**Re: 410-416 Victoria Avenue - DPHI Response to Submission 4th June 2025 & Willoughby City Council Letter 2nd June 2025**

This letter provides commentary and clarification in response to the points raised in the Willoughby City Council (WCC) Letter dated 2<sup>nd</sup> June 2025, specifically the items detailed in Section 16.a.iii Stormwater Management.

REV. B
DRAWING NO. DA 252

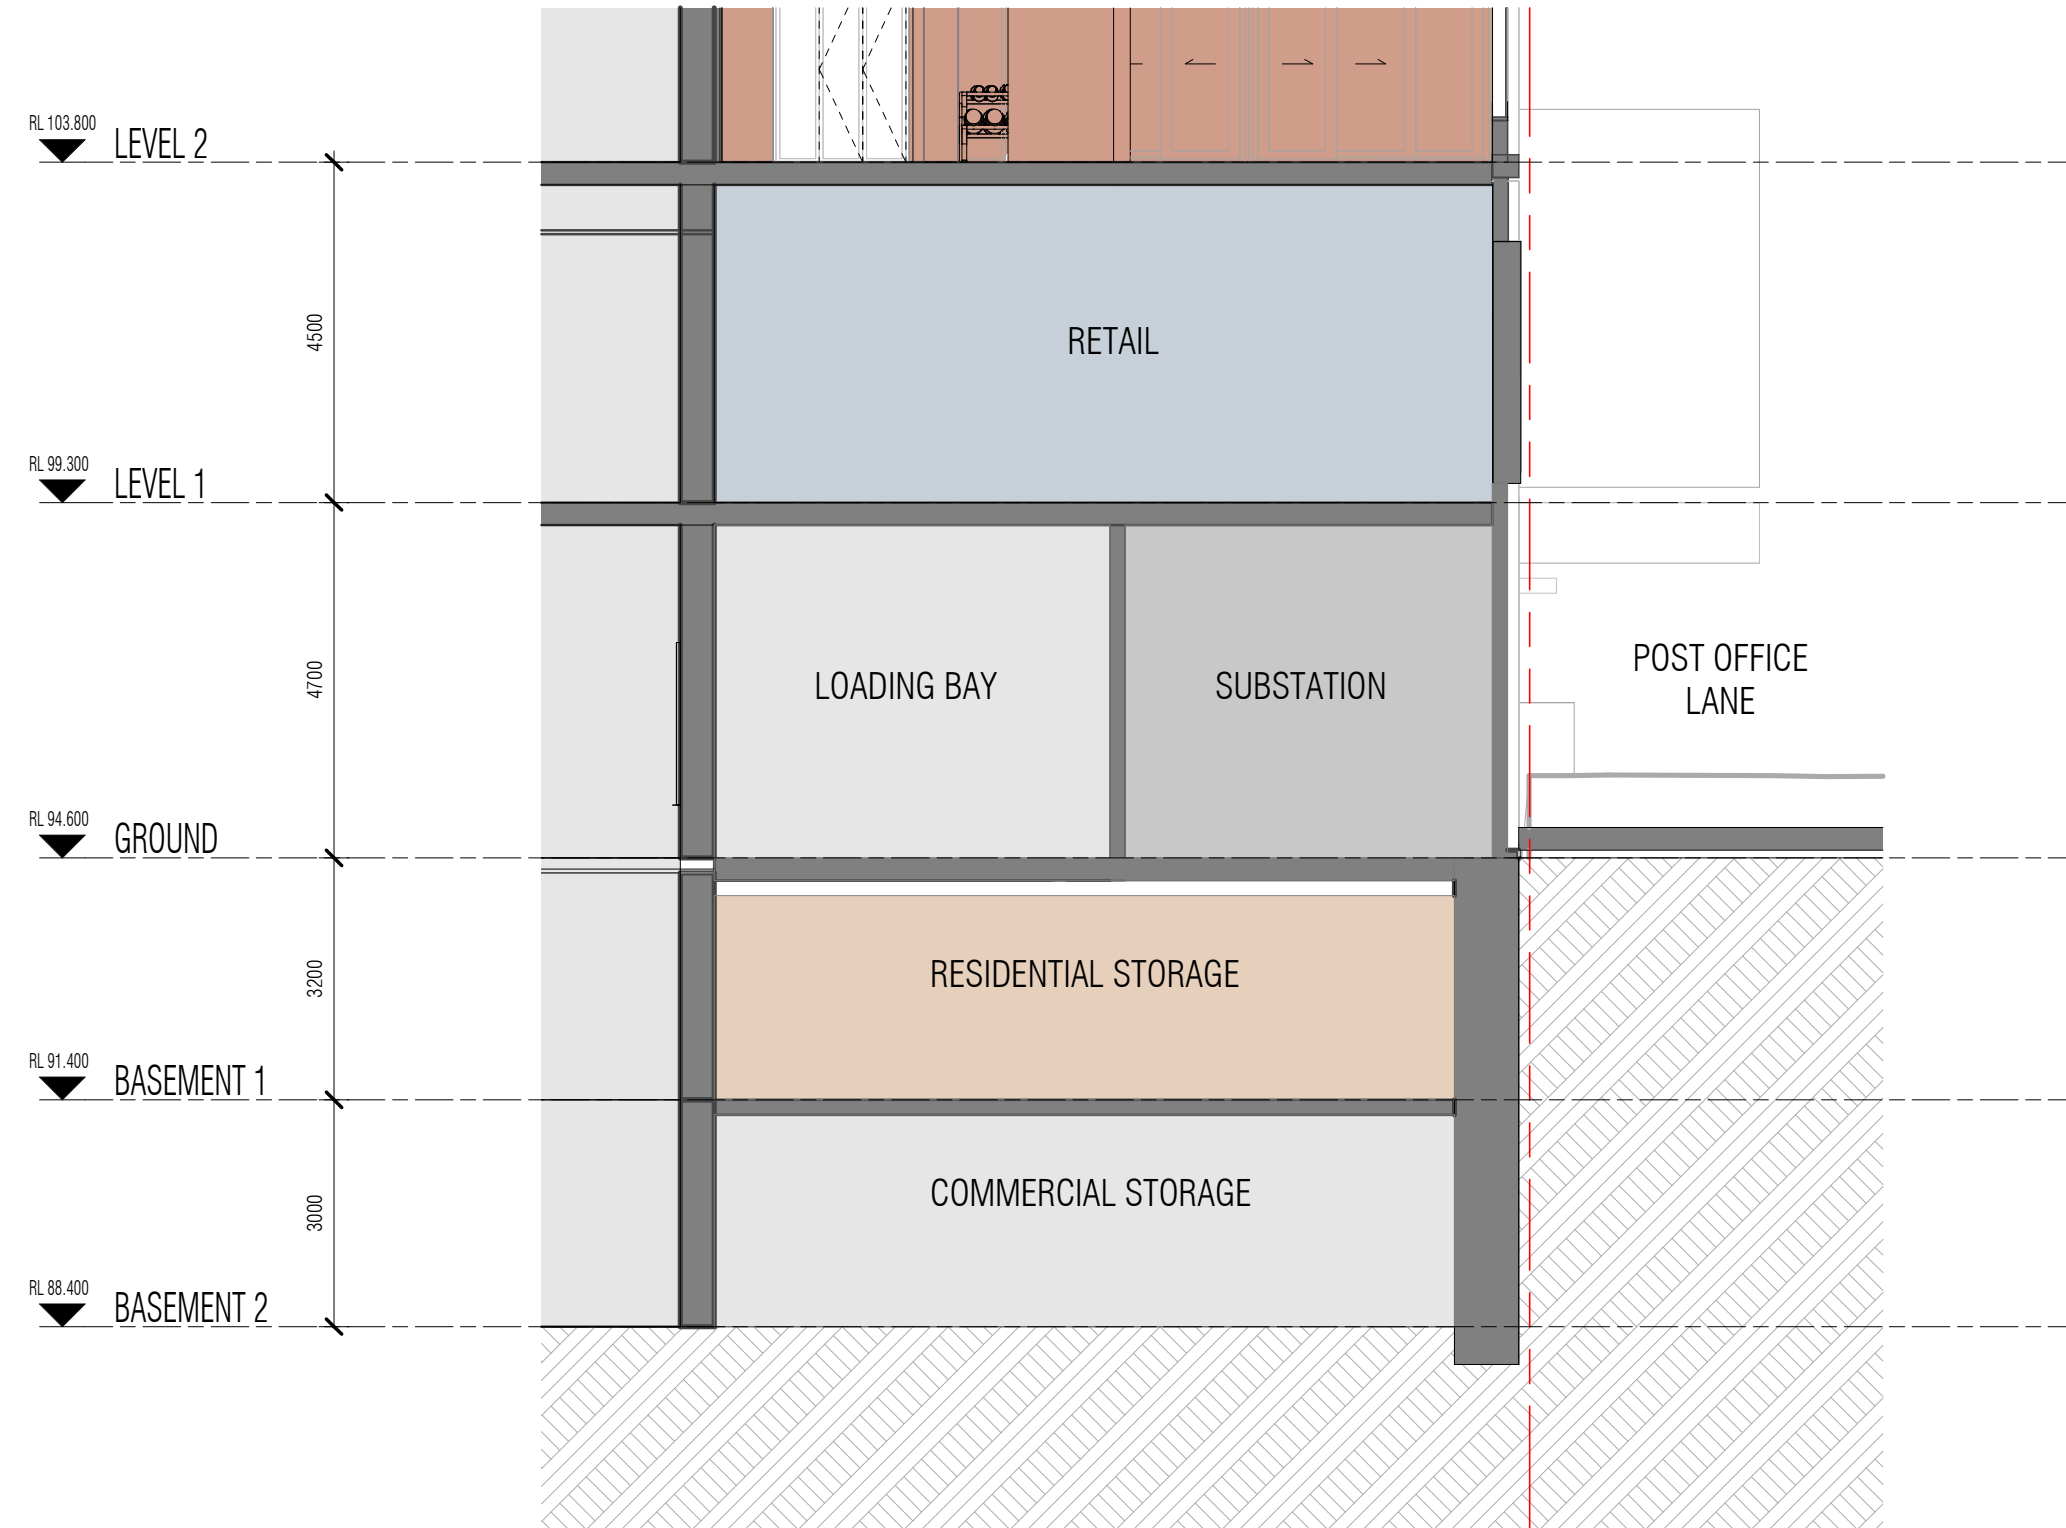
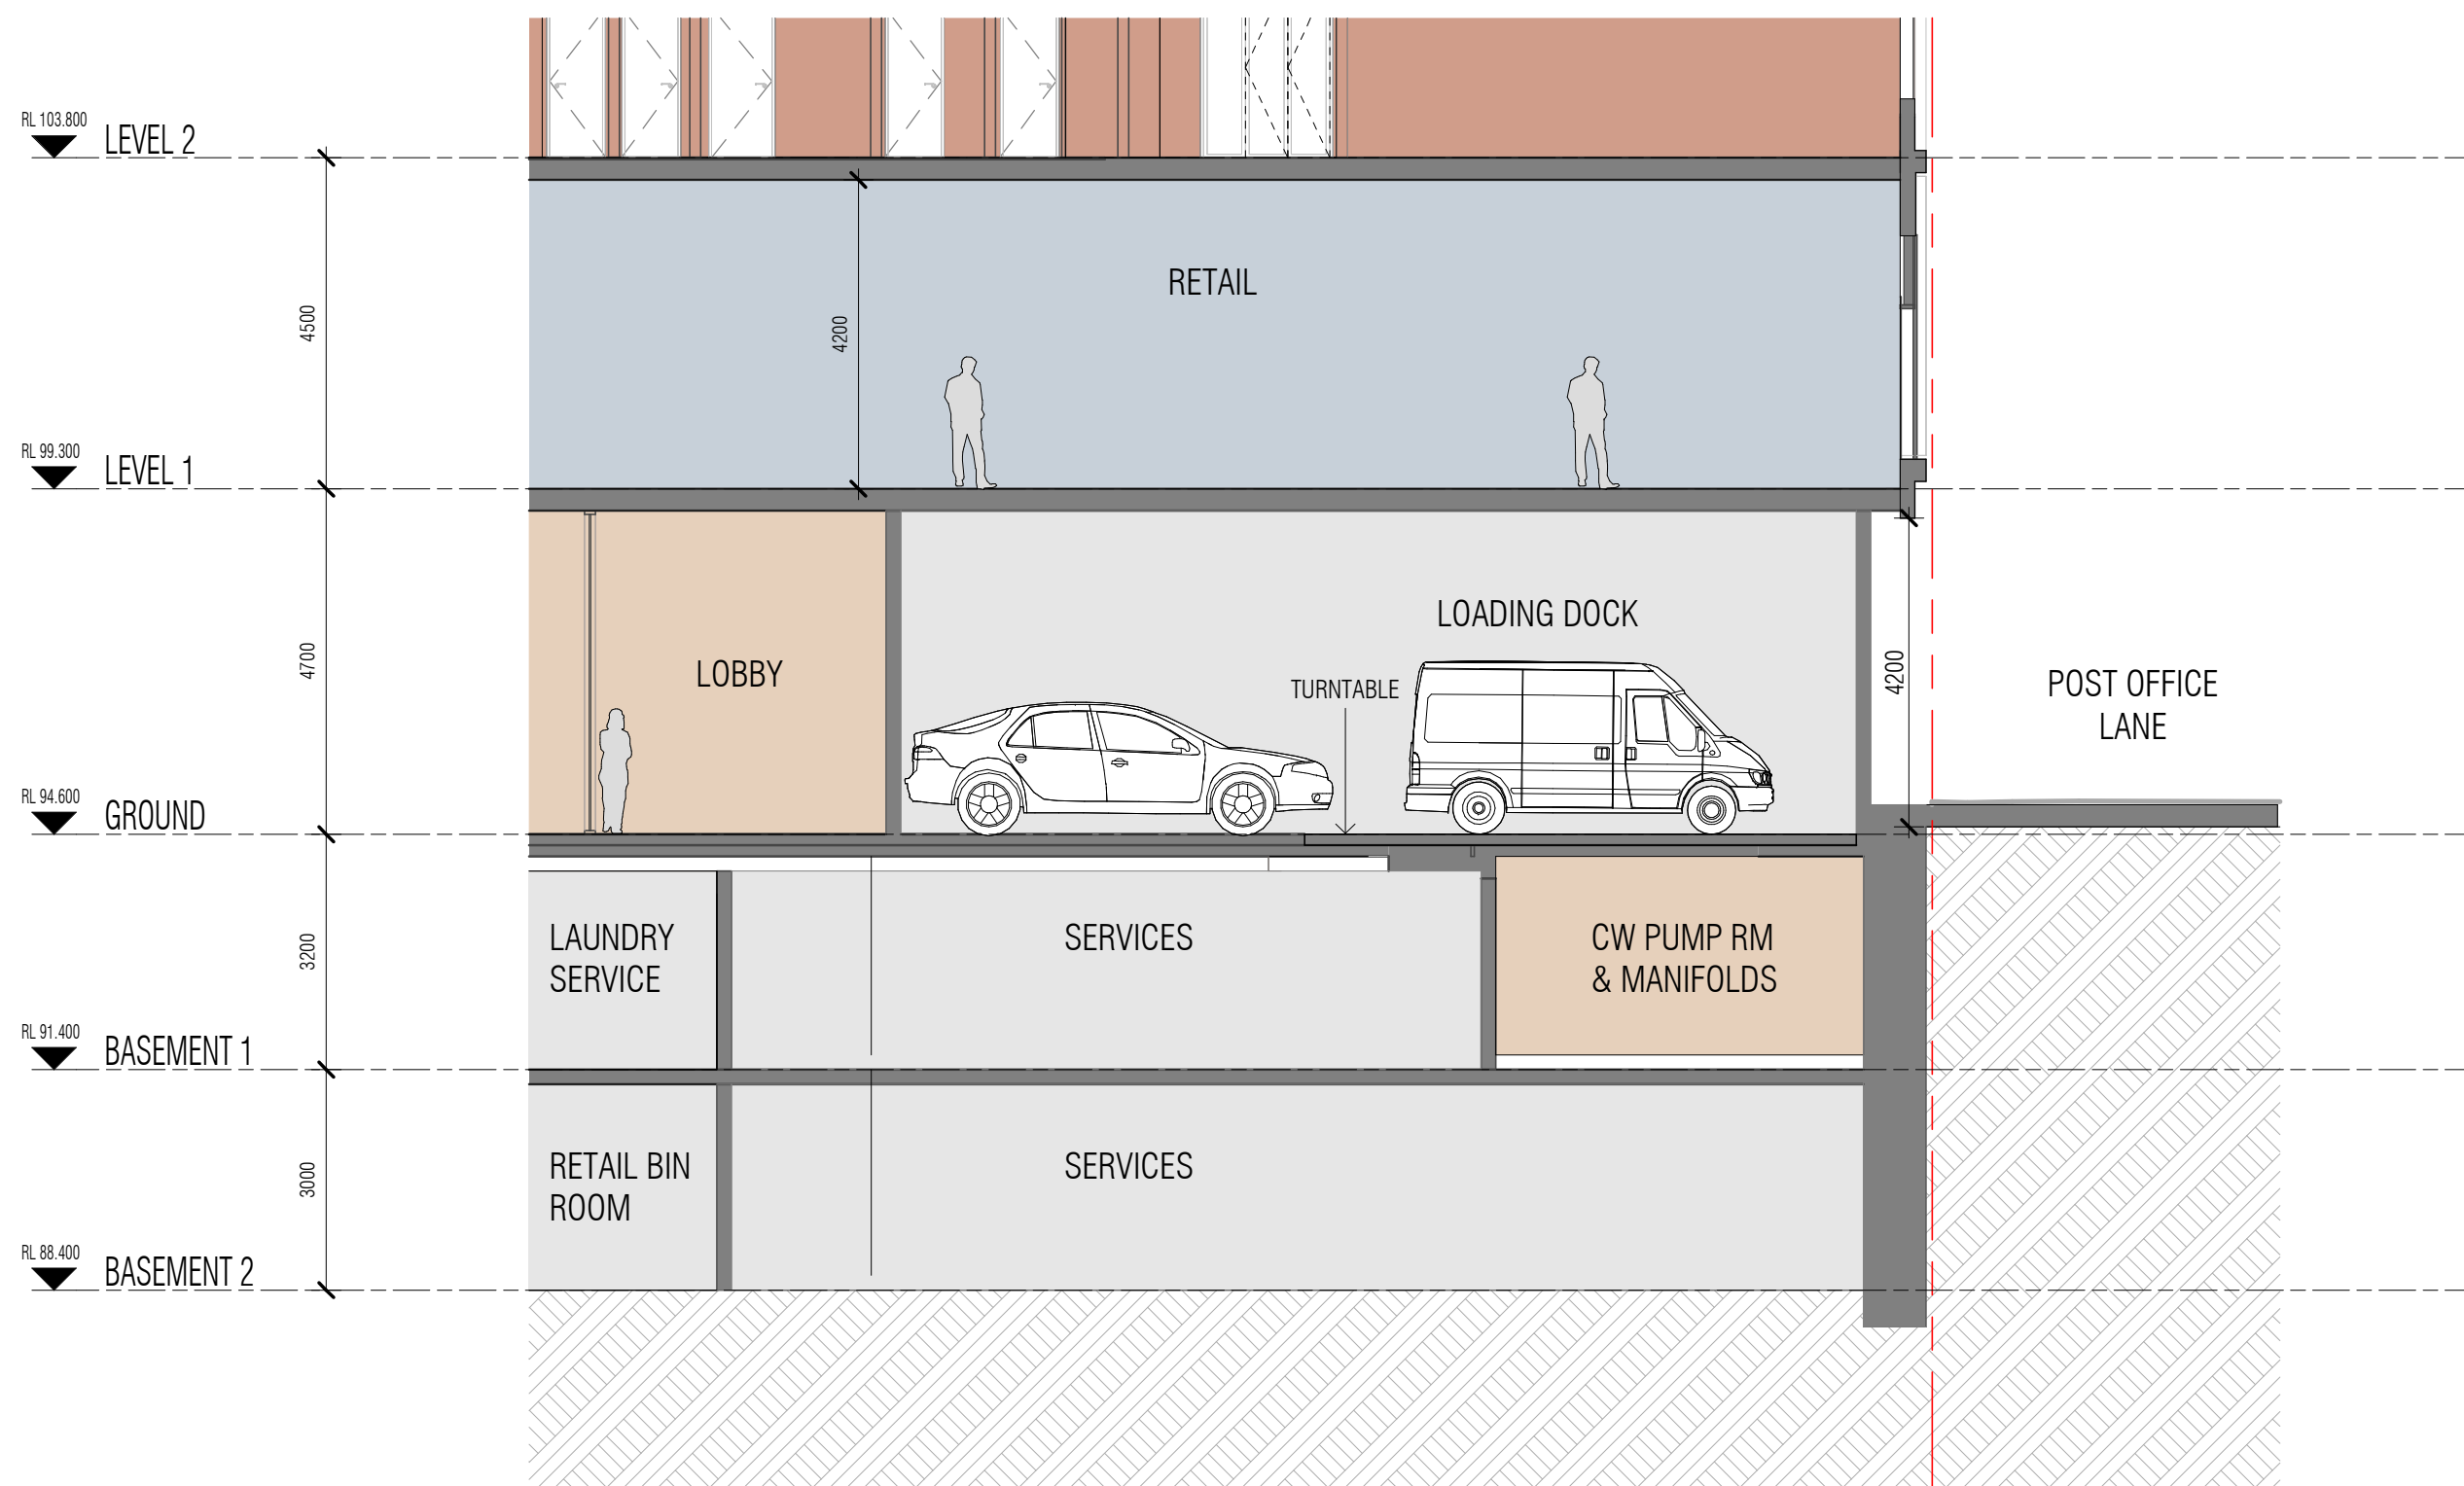
*WCC Comment: All below ground OSD tanks is not be located underneath habitable floors and are to have access grate diagonally opposite the outlet for ventilation and cleaning purposes. It is not demonstrated how access for maintenance requirements, preventing the mixing of pool water and OSD will be managed. It is not clear how the below ground OSD is accessible in line with AS 286.5- Safe working in confined spaces with no step iron provided for OSD tanks deeper than 900mm.*

The proposed OSD is not located below ground; instead, it is suspended at Level 2 slab level due to the shallow depth of the existing stormwater infrastructure along Victoria Avenue.

The pool coping is set at RL 104.66, which is 400mm higher than the adjacent pool terrace and the OSD top lids. This elevation difference ensures that stormwater cannot enter the pool. Additionally, the pool is fully covered, eliminating the risk of overflow from rainfall. Refer to architectural drawing DA252 for detailed pool levels.

Step irons can be installed in all OSD access lids, with details to be provided during the Construction Certificate (CC) design stage.
